Date: 16/05/2011
Our ref: 22607
Your ref: 10/01780/HYBRID

Proposal: Development of exemplar phase of NW Bicester Eco Town to secure full planning permission for 394 residential units and an energy centre (up to 400 square metres), means of access, car parking, landscape, amenity space, and service infrastructure and outline permission for a nursery of up to 350 square metres (use class D2), a community centre of up to 350 square metres (sui generis), 3 retail units of up to 770 square metres (including but not exclusively a convenience store, a post office and a pharmacy (use class A1), an Eco-Business Centre of up to 1,800 square metres (use class B1), office accommodation of up to 1,100 square metres (use class B1), an Eco-Pub of up to 190 square metres (use class A4), and a primary school site measuring up to 1.34 hectares with access and layout to be determined.

Location: Bicester Eco Town Exemplar Site, Caversfield, Oxfordshire.

## Bure Bridge and River Corridor Section (View north from NEAP)

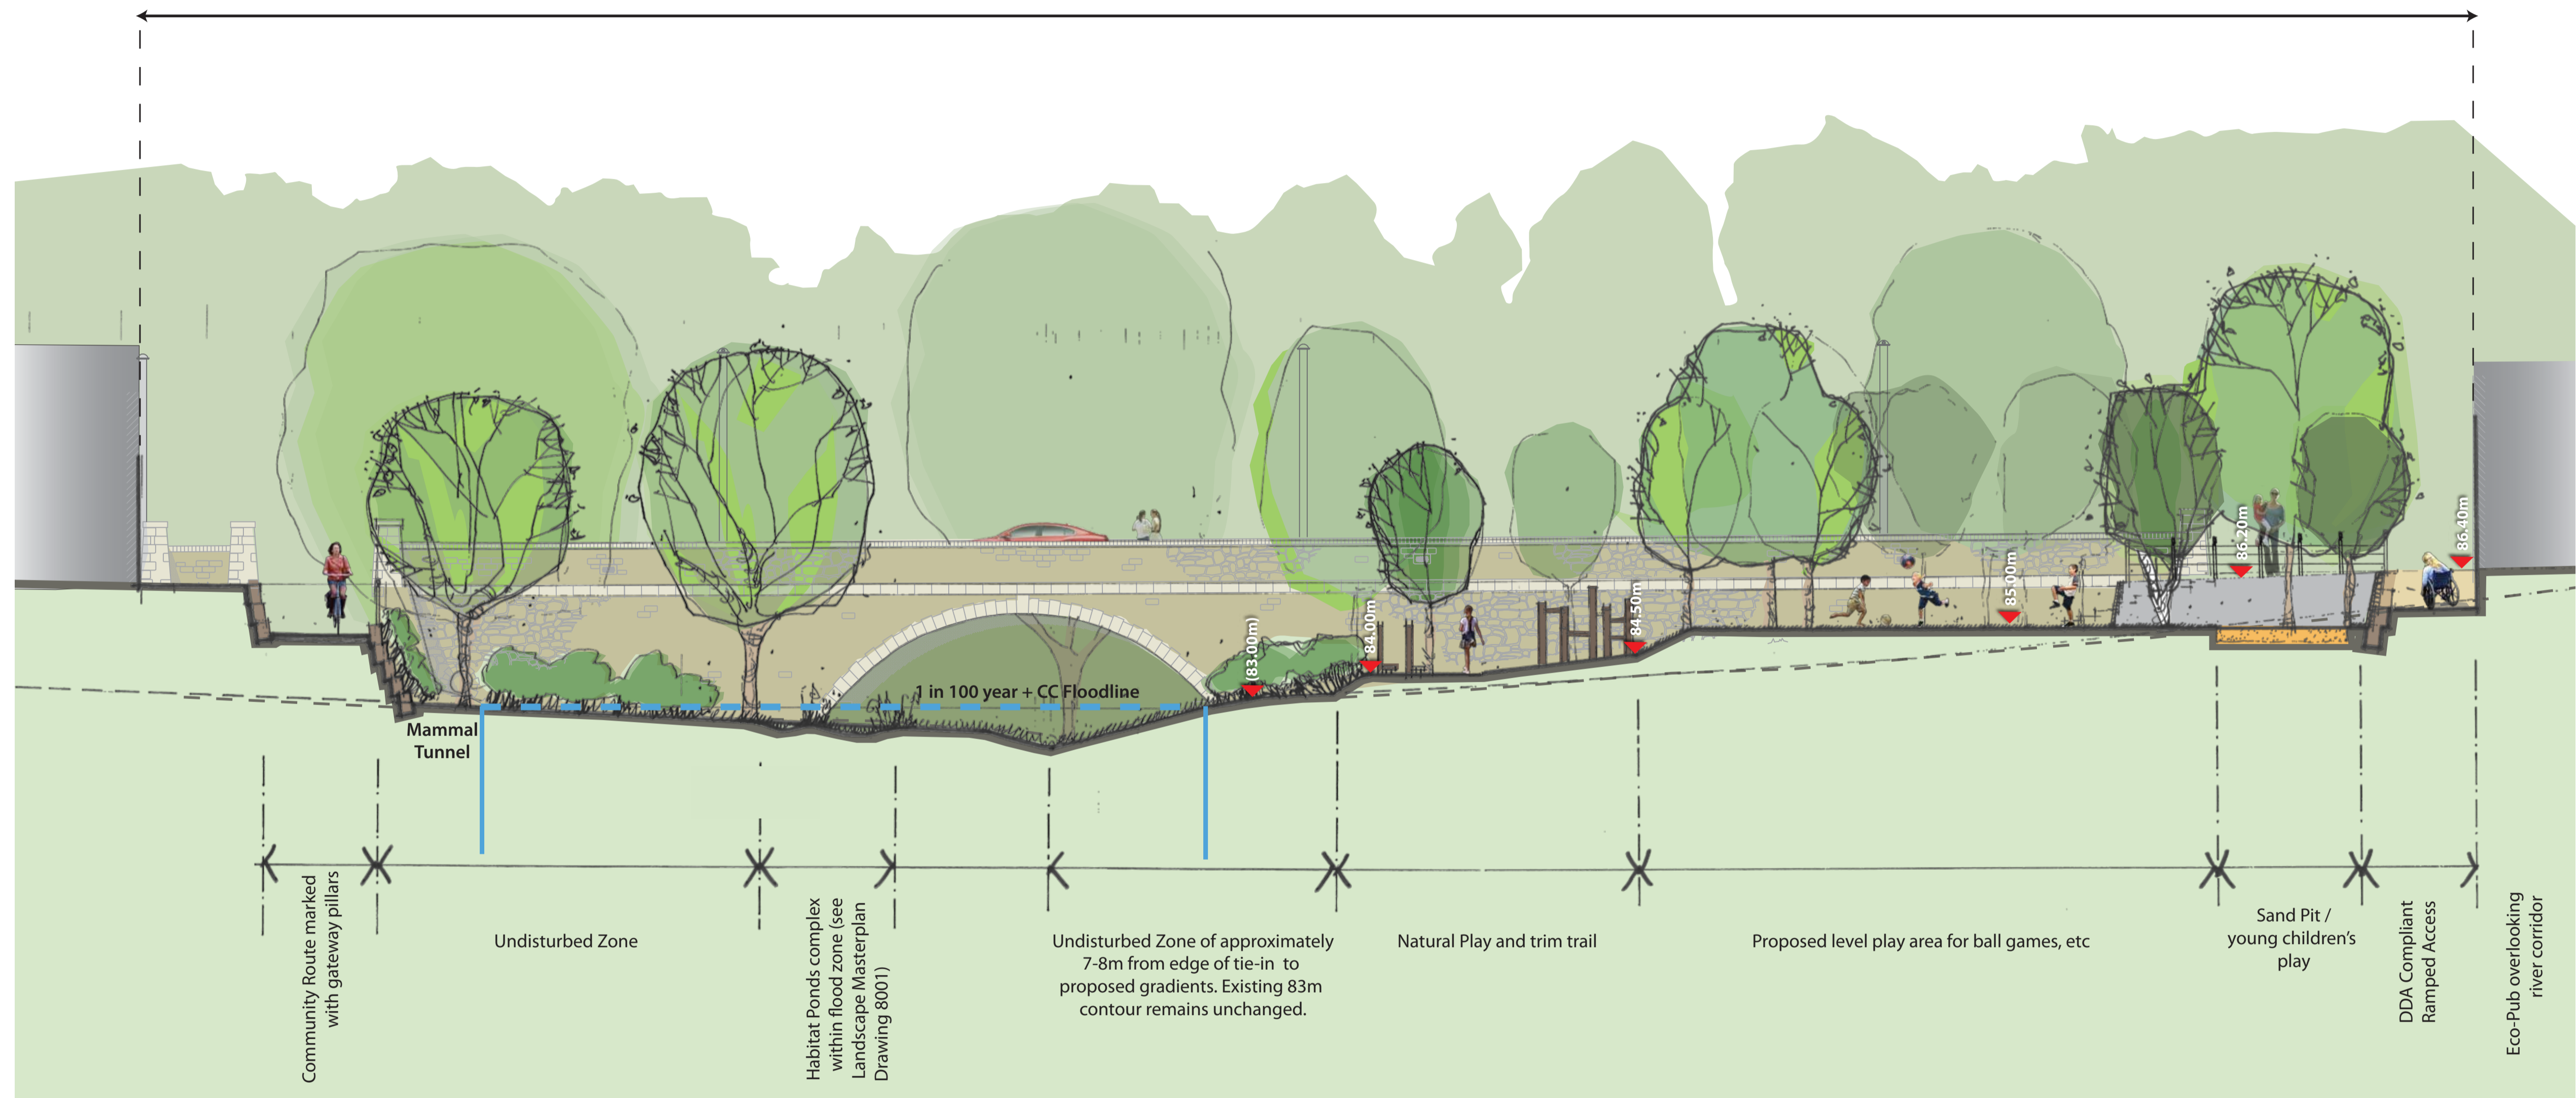
Natural England are pleased to see that a 60m wide corridor of semi-natural habitat has been proposed to buffer the watercourse. However this seems to be encroached by several elements of development, including the NEAP, the nursery garden, bungalow access and gabions, which all erode the value and effectiveness of the buffer. In particular the gabions and NEAP will alter the natural profile of the watercourse, and is less acceptable than the previous plans consulted on in January 2011.

It is still unclear as to how much lighting will be provided within the 60m corridor, in order to assess the suitability of a dark corridor for the bats travelling up and down the watercourse. This includes lighting of the bridges (both road and pedestrian), and of the adjoining NEAP, terrace and pub seating.

Natural England still believes that a clear span bridge would be more beneficial for the continuity of habitat, bat flight paths and views along the watercourse.
